## Application by Springwell Energy Farm Limited for an Order Granting Development Consent for the Springwell Solar Farm

### The Examining Authority's written questions and requests for information (ExQ1)

**Issued on 13 May 2025**

TITLE:
FIGURE 3.11B
VEGETATION REMOVAL PARAMETERS
SPRINGWELL EAST

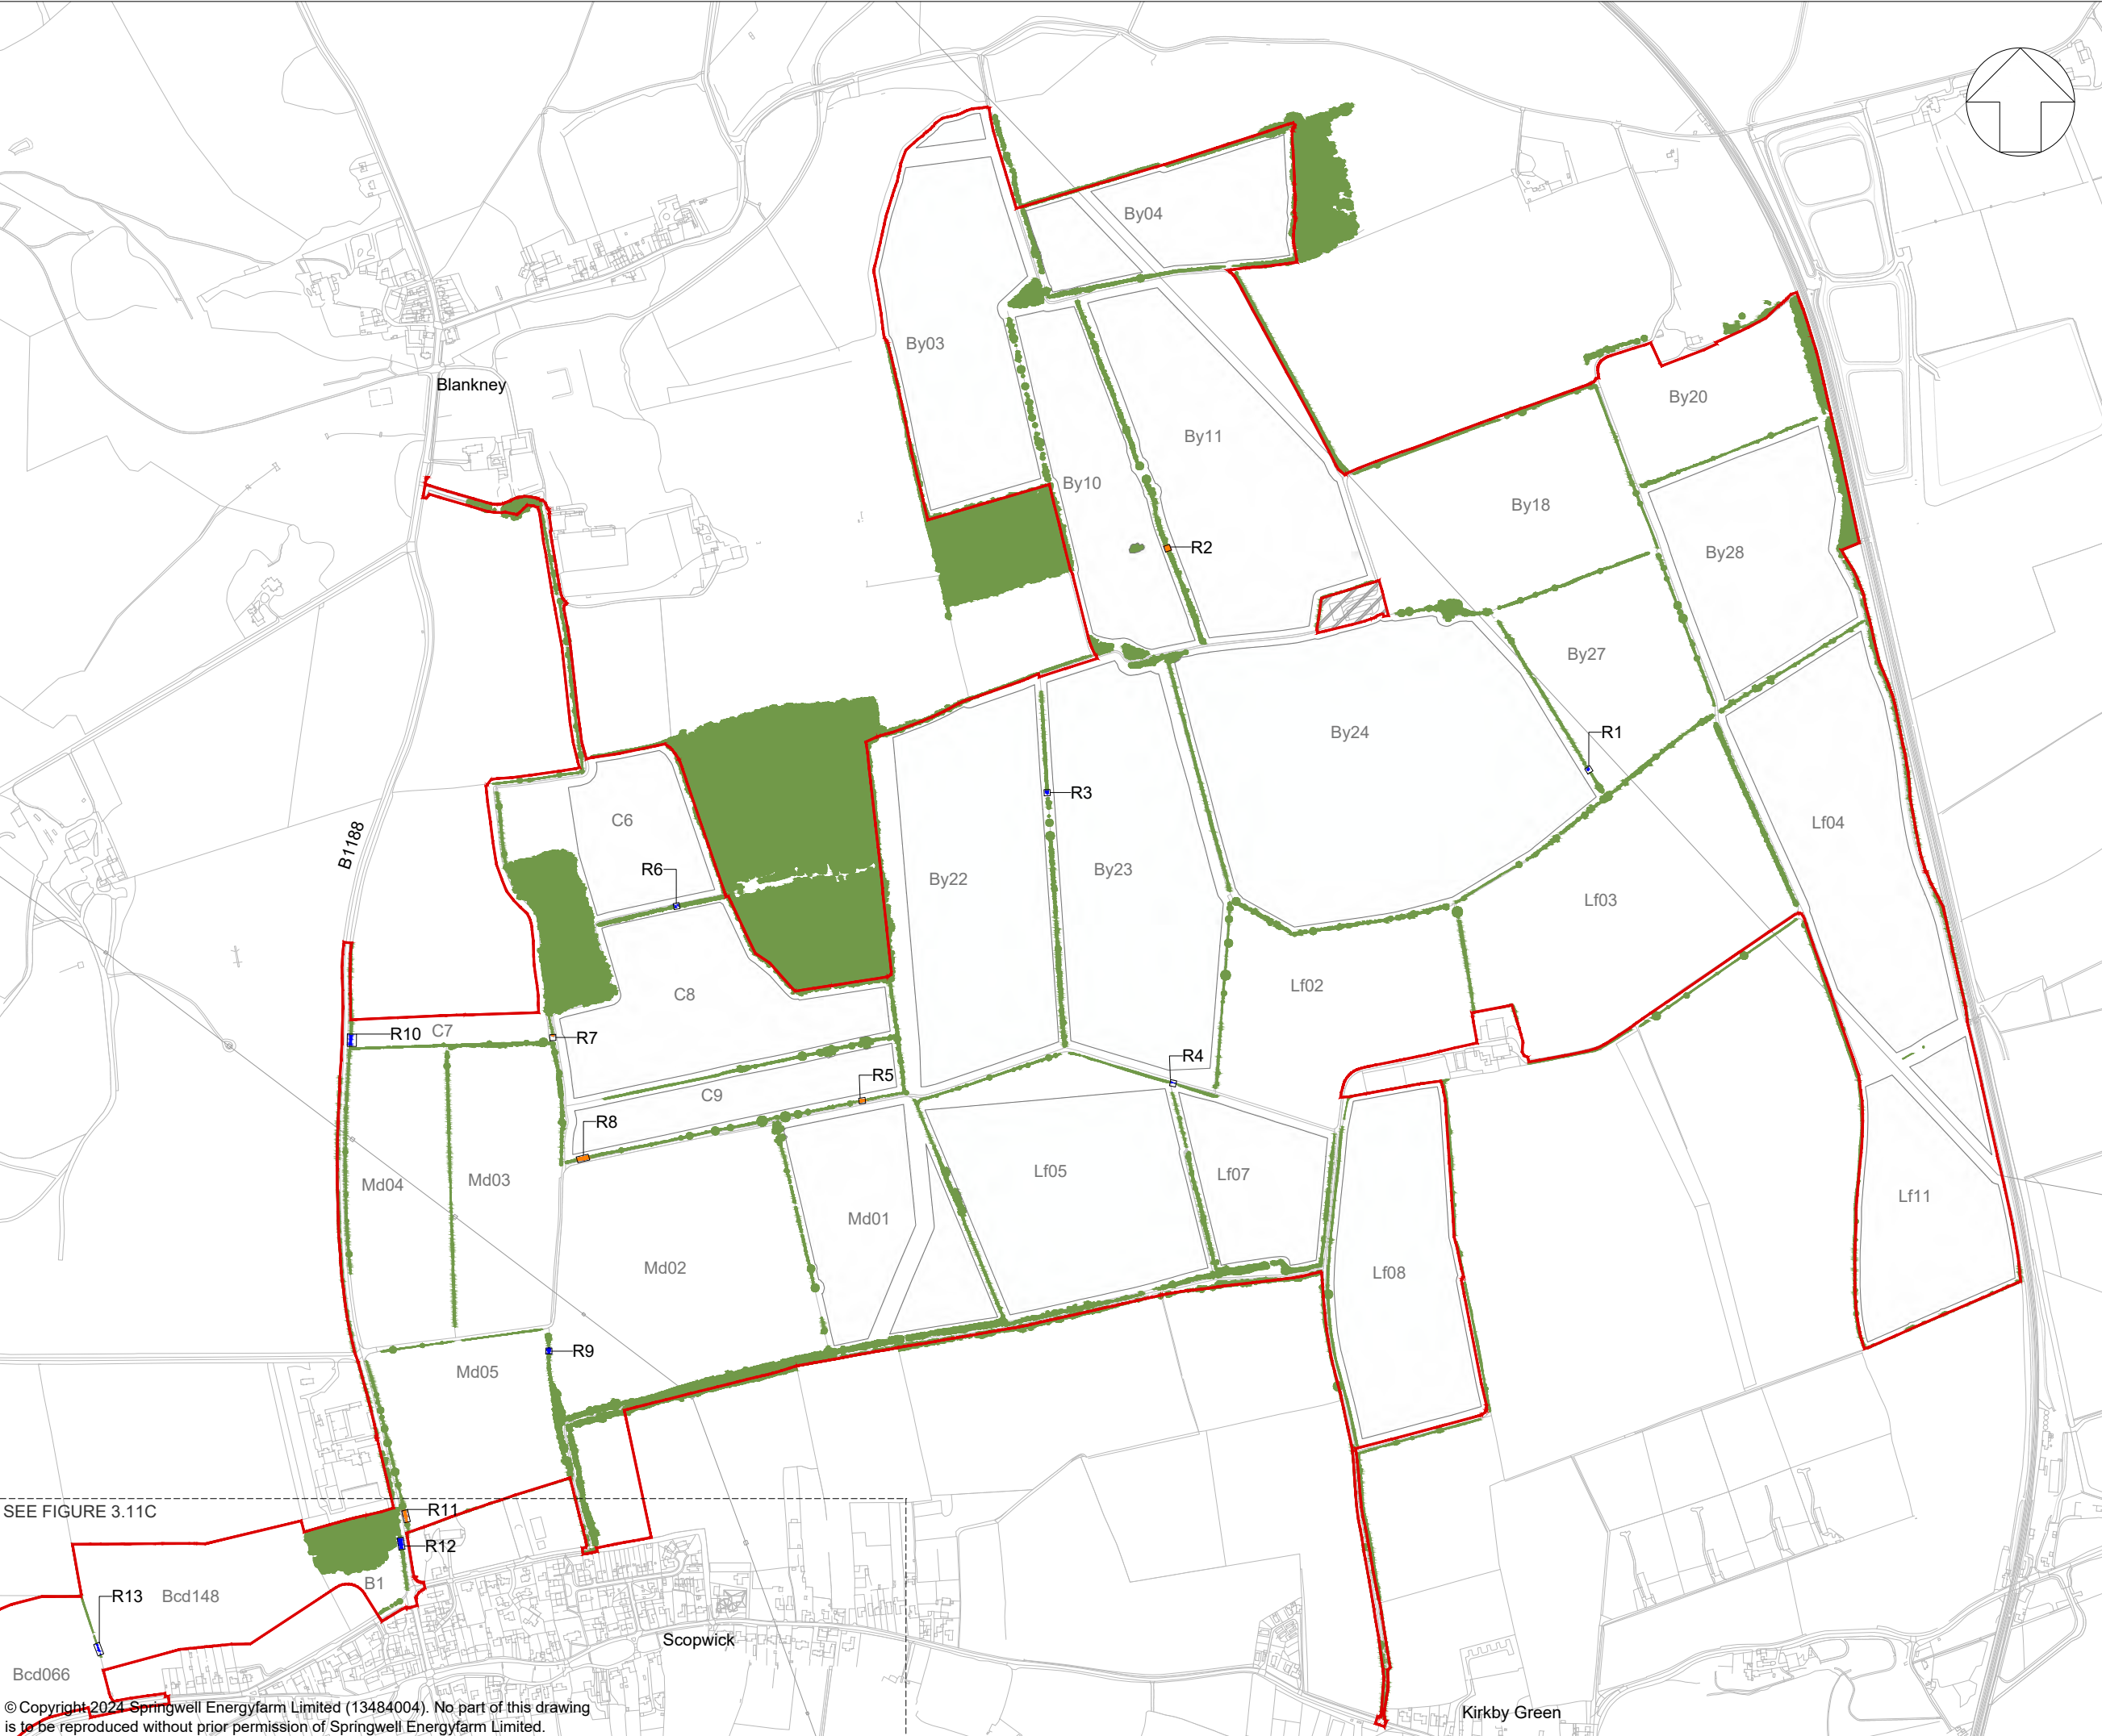
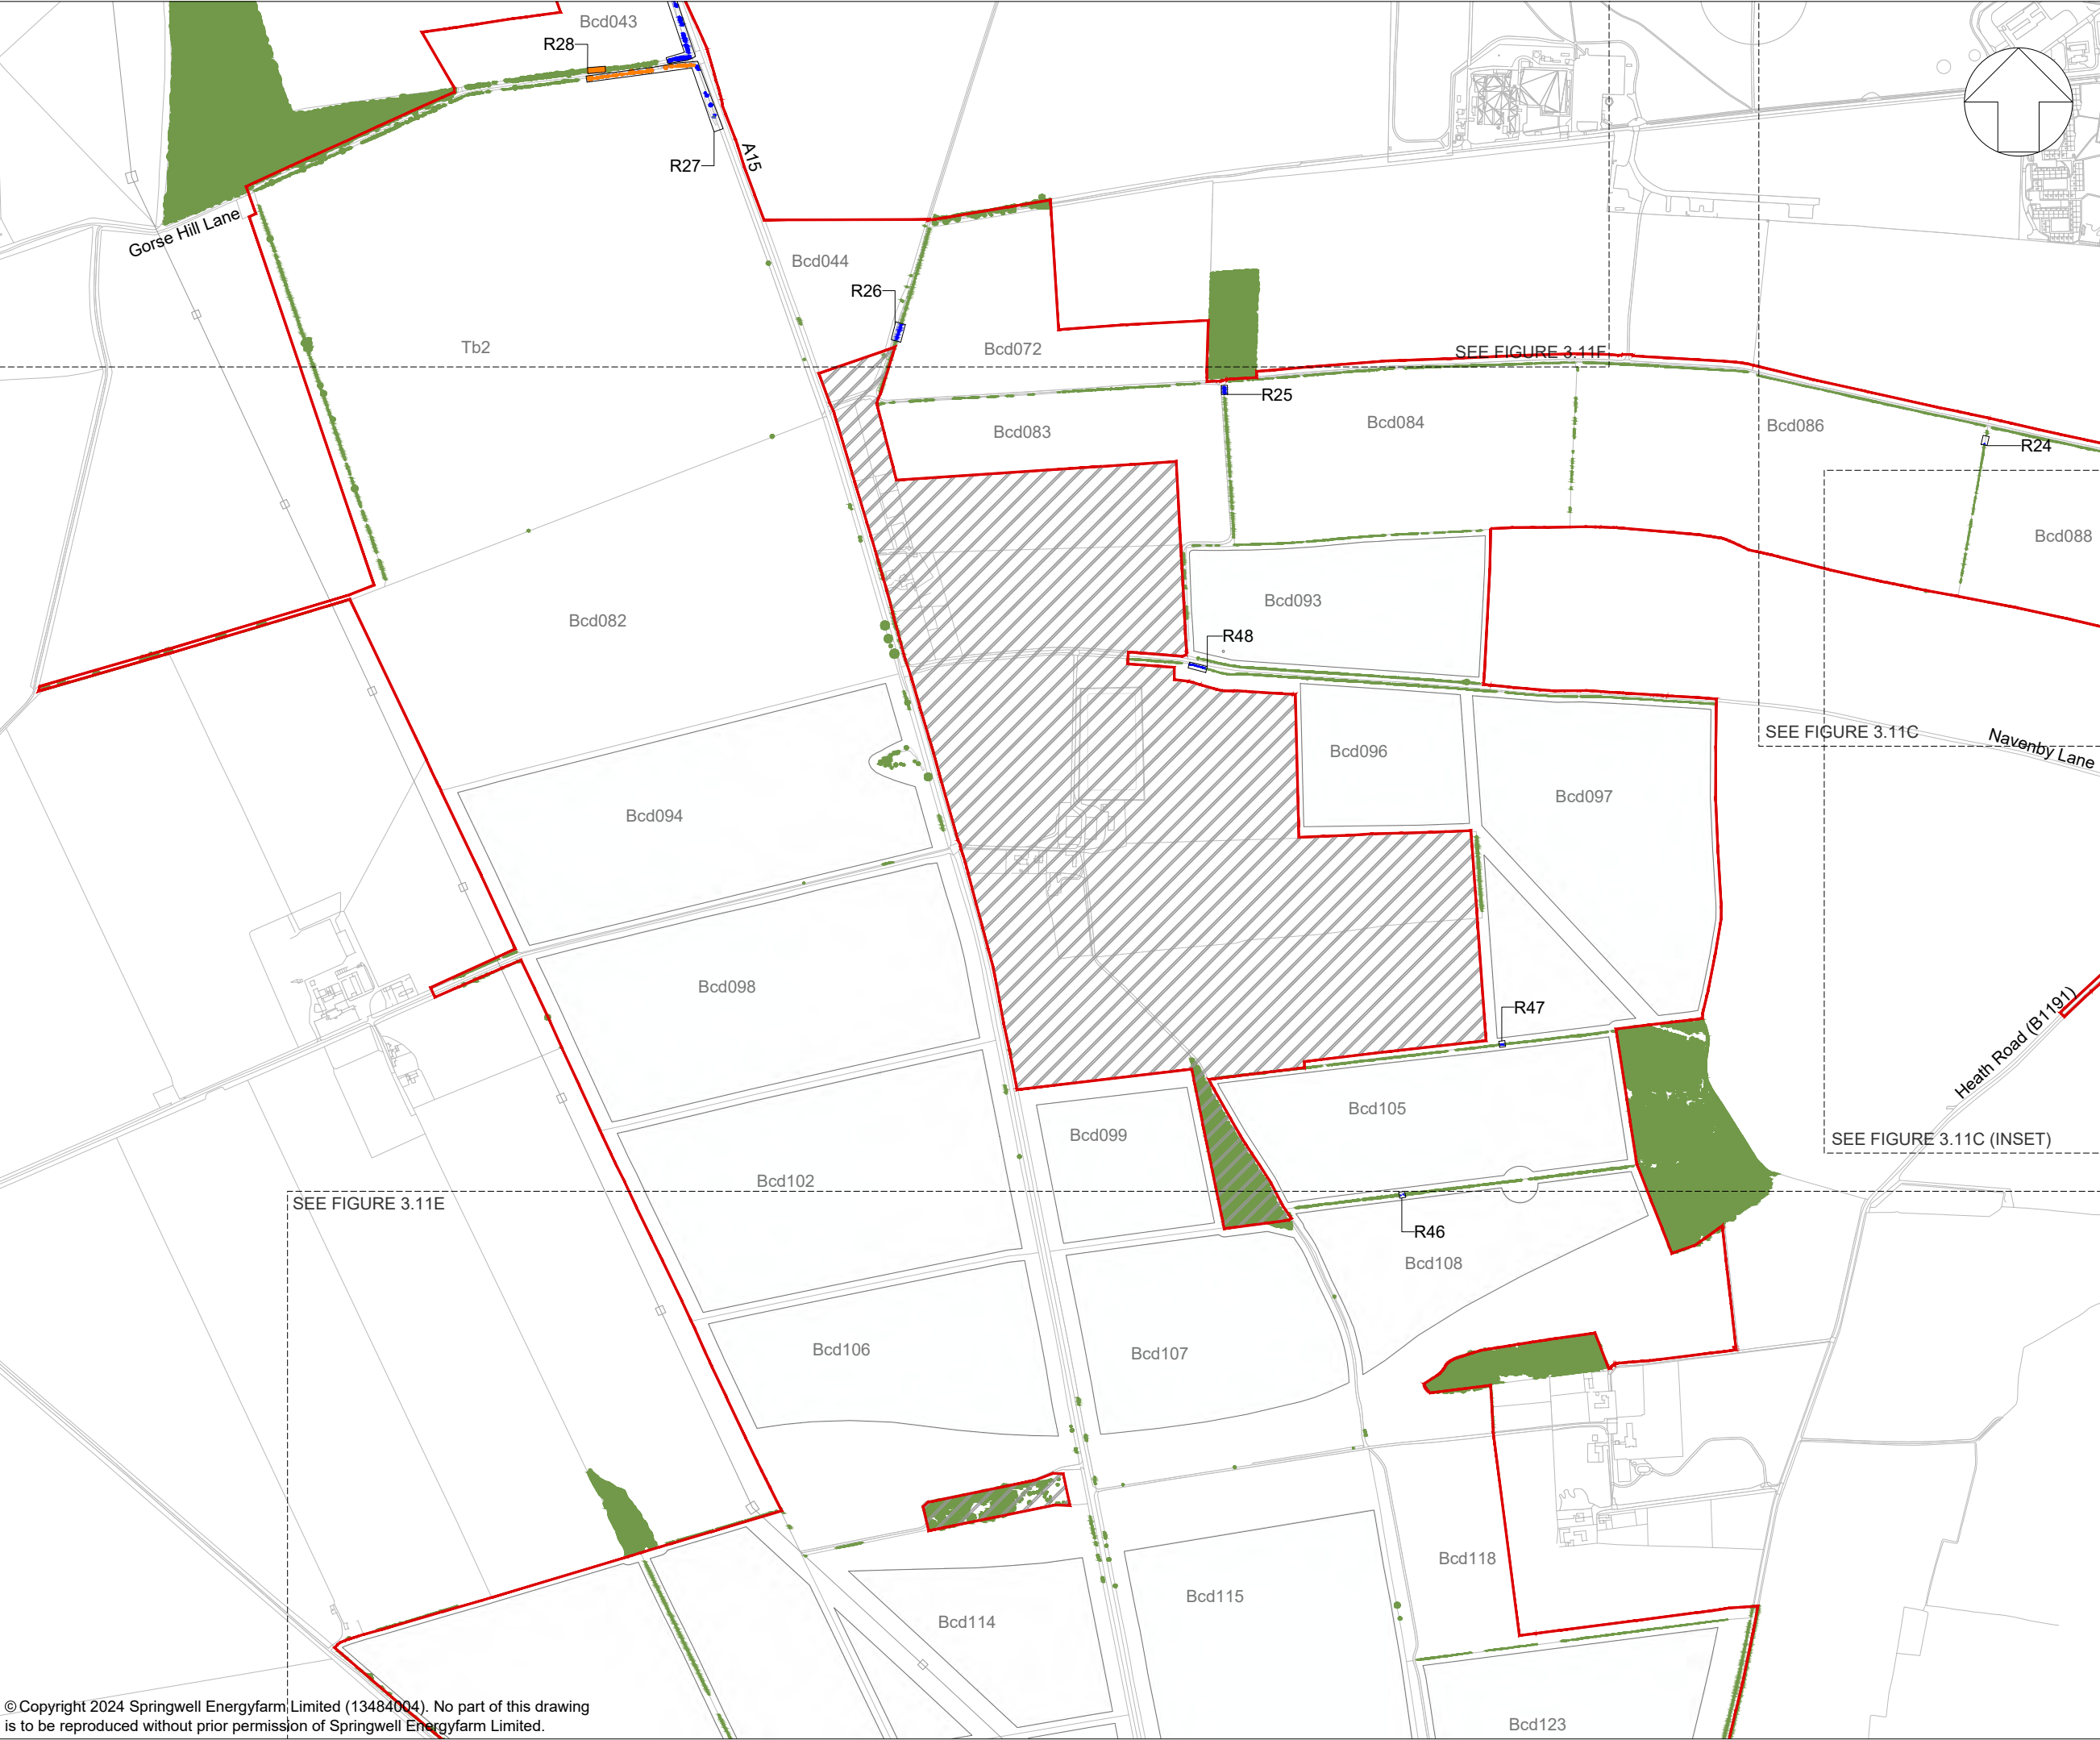
Q1.6.6	Applicant	<b>Cable Corridors</b> The Work Plans [APP-007] show large areas of land for cables (Work No. 6) within the Order Limits. The ES [APP-043] notes that multiple cables will be required across the Proposed Development and the width of these cable trenches will vary depending on the number of cables in each, up to 19 metres. The SoR [APP-015, Paragraph 4.4.3.] indicates that the location/ route of the cables is currently unknown and detailed surveys are required. However, the Vegetation Removal Parameter Plans [APP-60, Figure 3.11a to f] suggest that the locations of the cables (at least where it crosses field boundaries) are known.

ExQ1	Question to:	Question:
		Given that a maximum width of 19 metres is needed and the Vegetation Removal Plans suggest that the locations of the cables are known, justify how seeking CA powers over all of the land identified for Work No. 6 accords with the need for the SoS to be satisfied that the Applicant is seeking no more land than is reasonably required for the purposes of the Proposed Development.
Q1.6.7	Applicant	<p><b>Powers of Acquisition – Permanent Rights</b></p> <p>Article 24 of the dDCO [APP-012] is drafted to enable compulsory acquisition of new rights over <u>all</u> of the Order land, with a schedule which limits the compulsory acquisition power in defined plots to the defined rights listed in Schedule 9.</p> <p>Provide further justification for this approach and demonstrate that persons with an interest in the Order land, particularly for plots identified in the Land Plans [AS-004] and BoR [AS-007] for temporary possession were aware that undefined new rights were being sought over <u>all</u> of the Order land and were consulted on that basis.</p>
